CITY OF ALBUQUERQUE

August 26, 2013

Re: Boulders Phase III (B10/D001D)
Grading and Drainage Plan
Engineer's Stamp Date: 8/18/2013

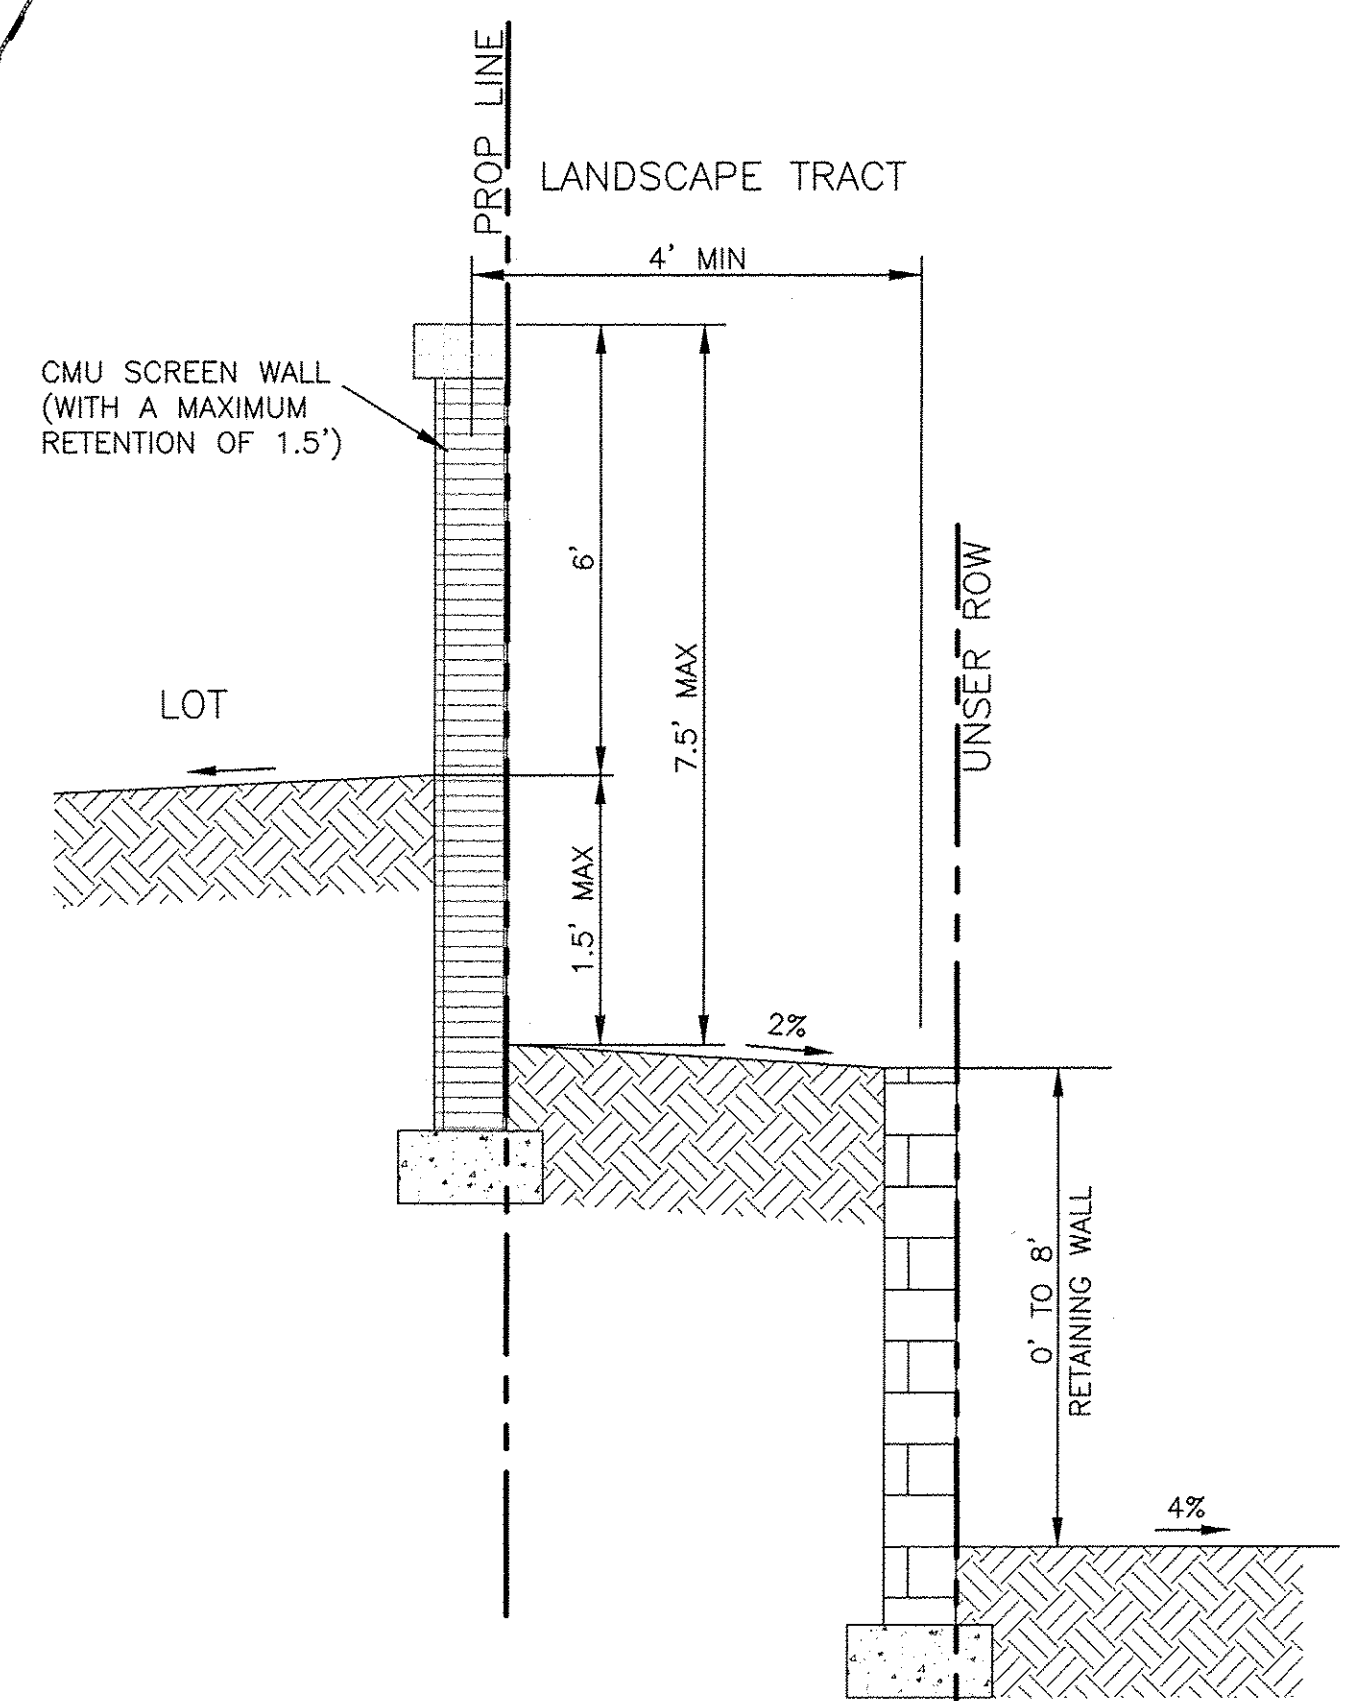
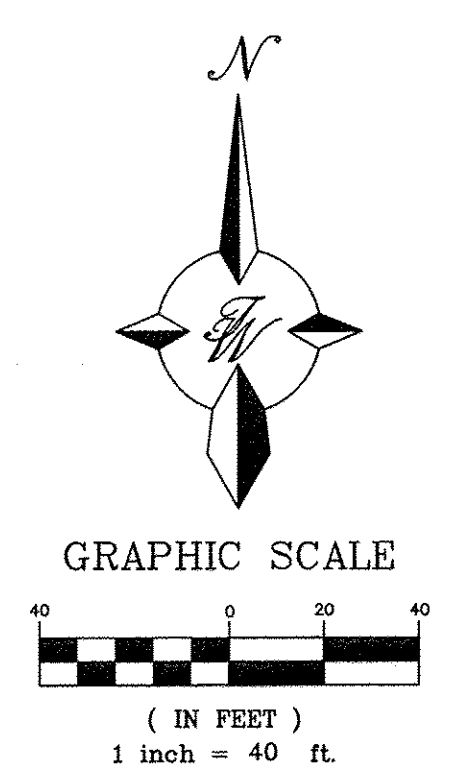
- Existing contours are not shown clearly.
- Update storm drain pipe sizes on the plan.
- Construction easement will be required south end of the Stoney Draw Road.
- Include top and bottom elevations for the proposed floodwall on Sheet 2.
- Fix the finish contour for the lots where the runoff appears to drain to the back.
- Provide the Bench Mark Information on the plan.
- Include a note on the plan that "All Curb & Gutter for Phase III are Standard Curb and Gutter per City Standard Drawing # 2415A".
- Will there be any easement required for the construction of the 24" pipe across the APS site?
- Re-submit the drainage report with all the recent drainage calculations. Please include the inlet and pipe capacity calculations as well.
- Provide Erosion Sediment Control Plan.
